Re. Angus Place Mine Extension Project (SSD 5602) Amended Development Application

Greater Blue Mountains World Heritage Area Advisory Committee

27 April 2020

**ANGUS PLACE COLLIERY**  
 CLIFFS, MINOR CLIFFS, PAGODAS &  
 STEEP SLOPES

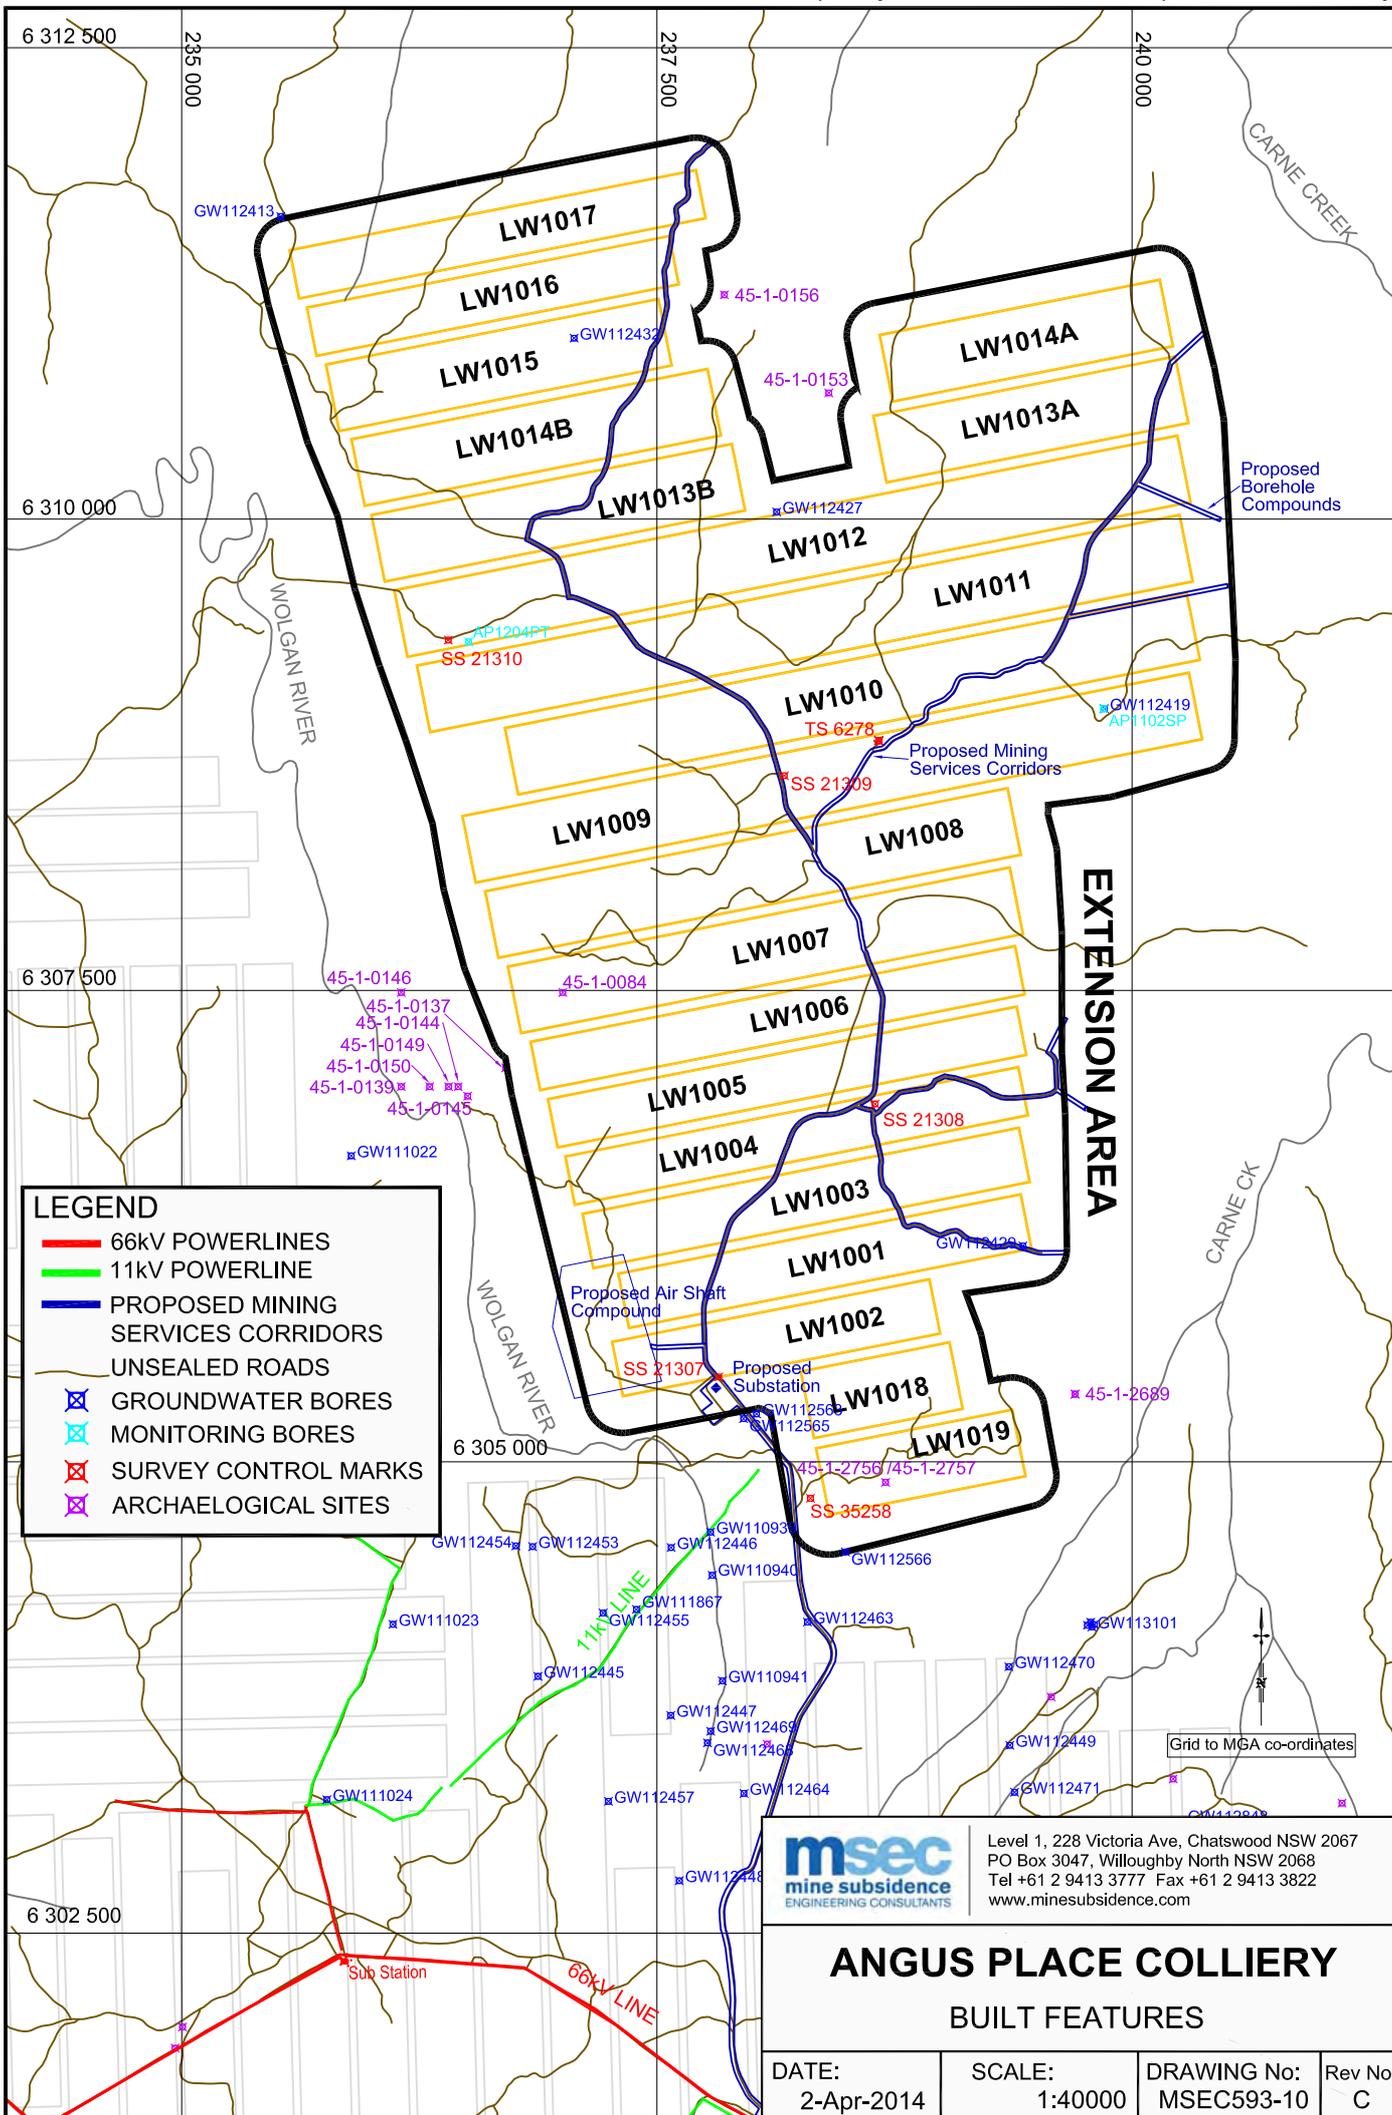
The potential for damage to the dramatic cliff-faces and pagodas in the adjoining WHA, including along the Carne Creek gorge, as a result of mining related subsidence, is of serious concern and the longwall panel design and mine layout must ensure that risk of subsidence related impacts is avoided. Past longwall mining in the region has resulted in significant and well documented damage to cliff-faces and pagodas. The proposed longwall panel width of 360 m is excessive and must be reduced significantly so as to avoid the risk of damaging subsidence.
